From: Rael, Rudy E.
Sent: Thursday, January 19, 2017 9:24 AM
To: 'David Soule (david@riograndeengineering.com)'
Subject: 6401 Picardia

Based upon the information provided in your submittal received 1/17/17, the above referenced Grading and Drainage plan dated 1/16/17 cannot be approved for Grading Permit until the following comments are addressed:

ENGINEER'S SEAL  1/19/17 DAVID SOULE P.E. #14522	LOT 29, BLOCK 8, UNIT 22 VOLCANO CLIFFS	DRAWN BY JDG
	GRADING AND DRAINAGE PLAN	DATE 01-15-2017
 Rio Grande Engineering 1606 CENTRAL AVENUE SE SUITE 201 ALBUQUERQUE, NM 87106 (505) 872-0999		SHEET # 1 OF 1
		JOB #

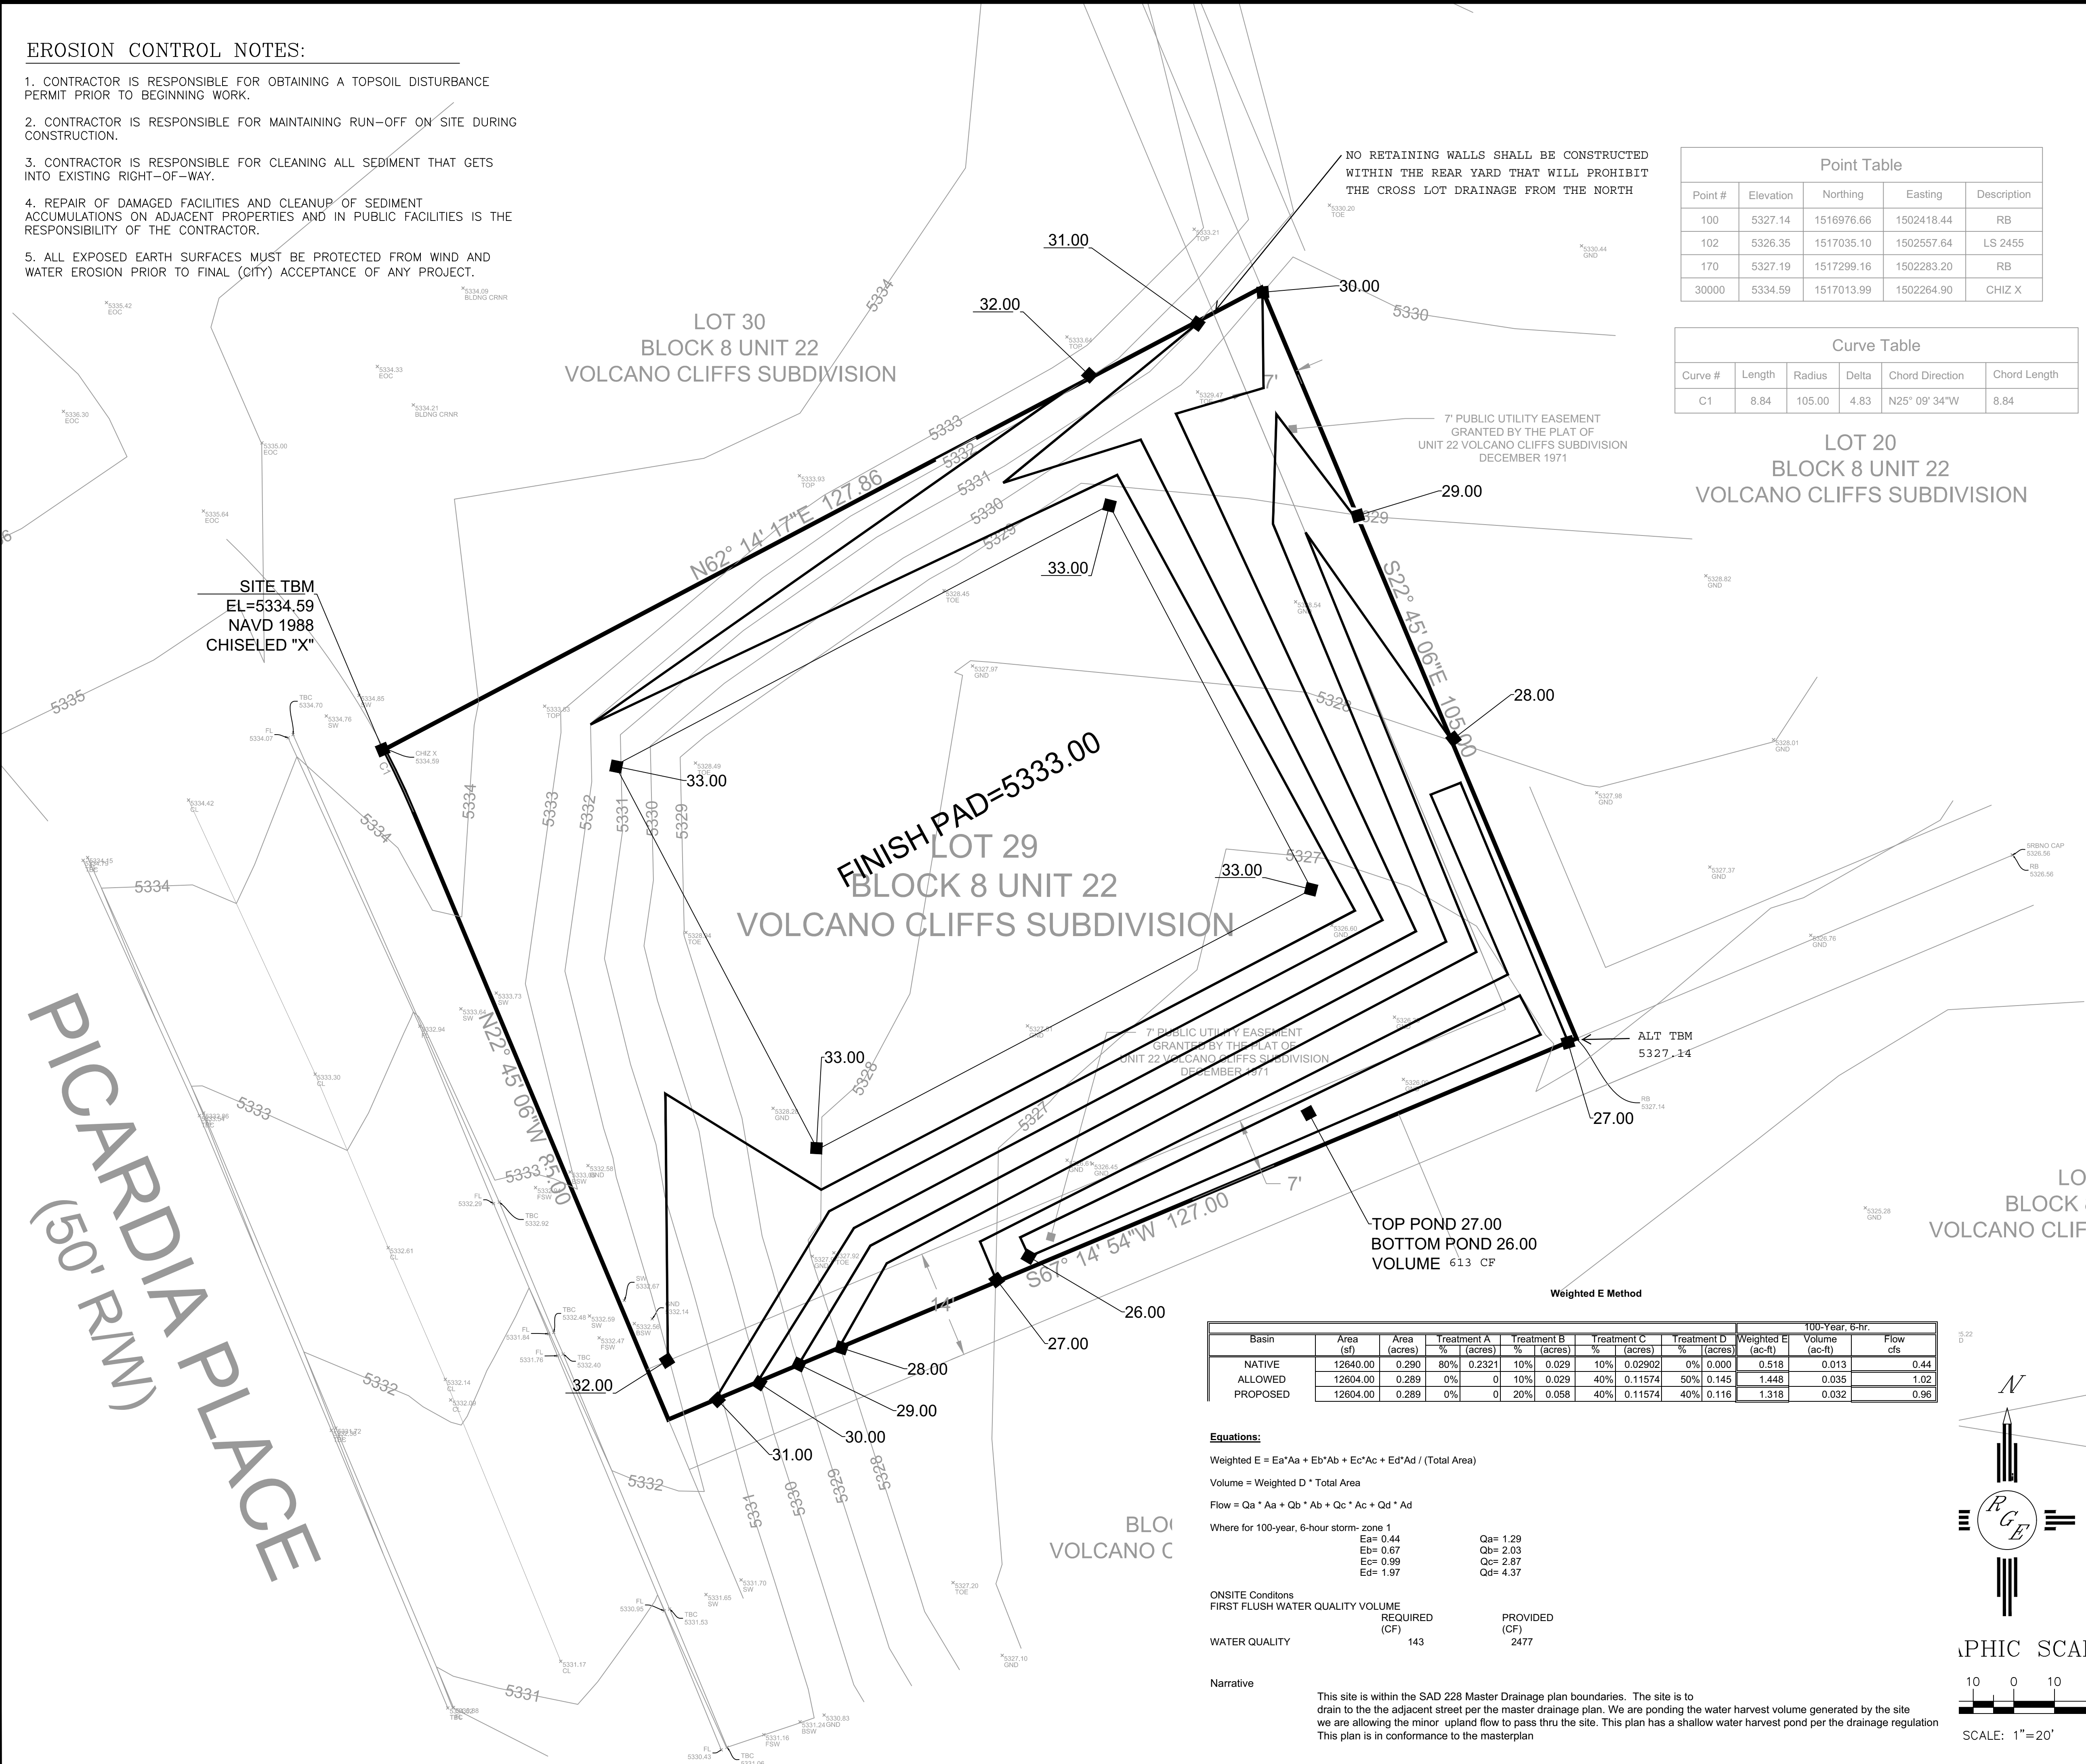
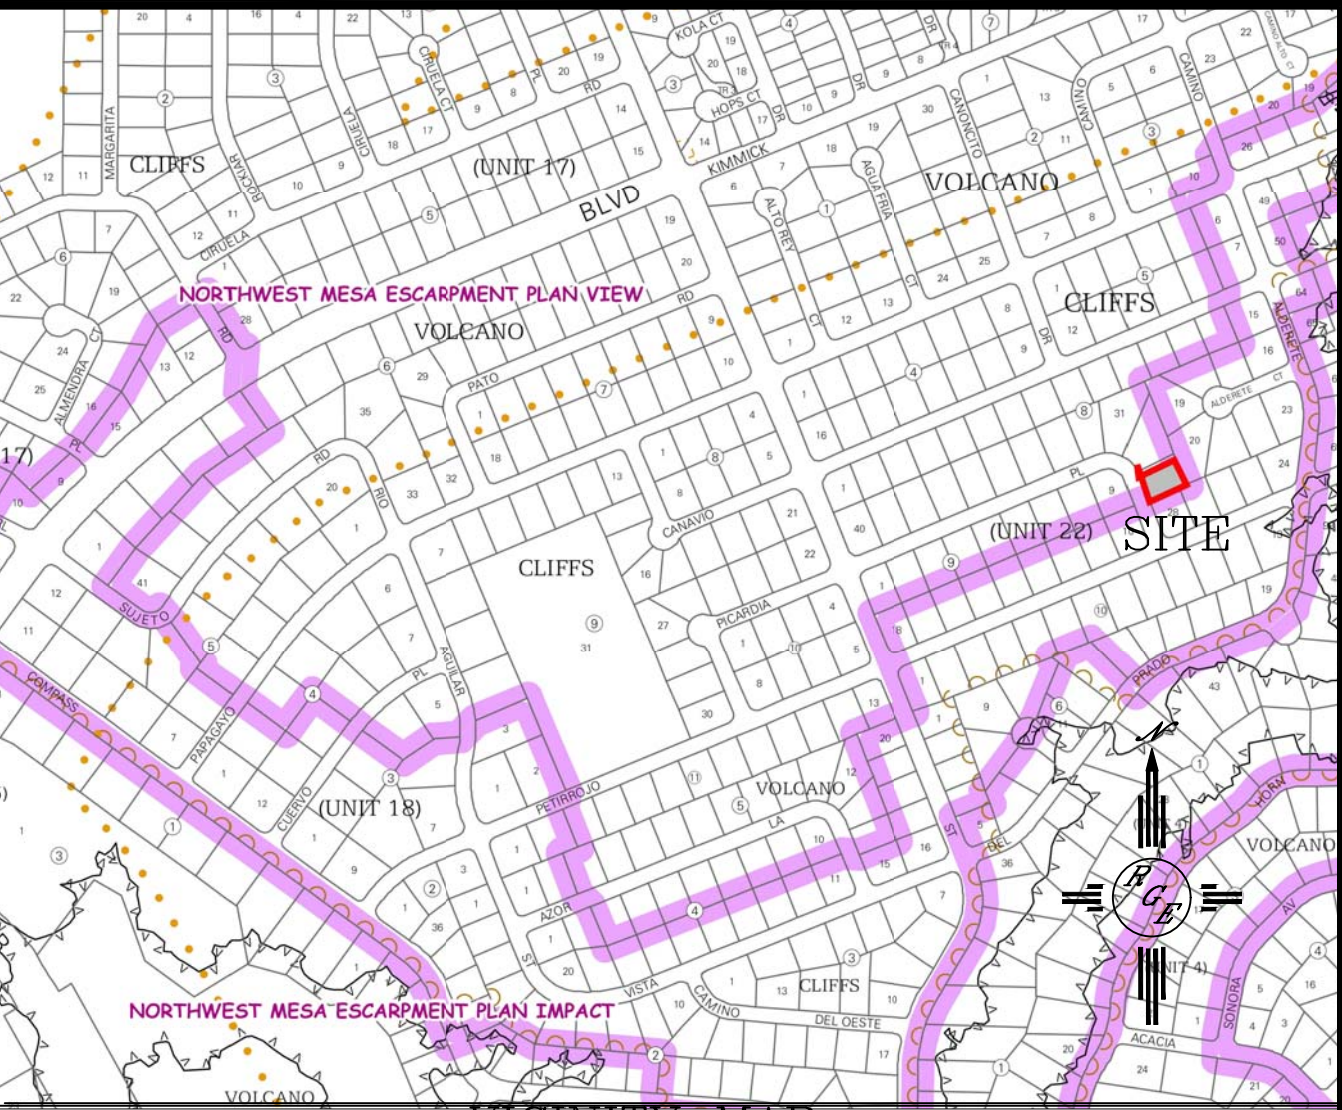
- Provide a note stating that future garden walls require a separate permit and this plan should be used for their placement.
- Also state that future garden walls require an opening 3" above grade in the NW corner and SW corner.
- Provide a note stating retaining walls are not allowed in the rear yard unless a swale is provided so flows may pass from the property to the north into their property and to the south property.
- Provide a statement that a pad certification is required before a building permit is given.
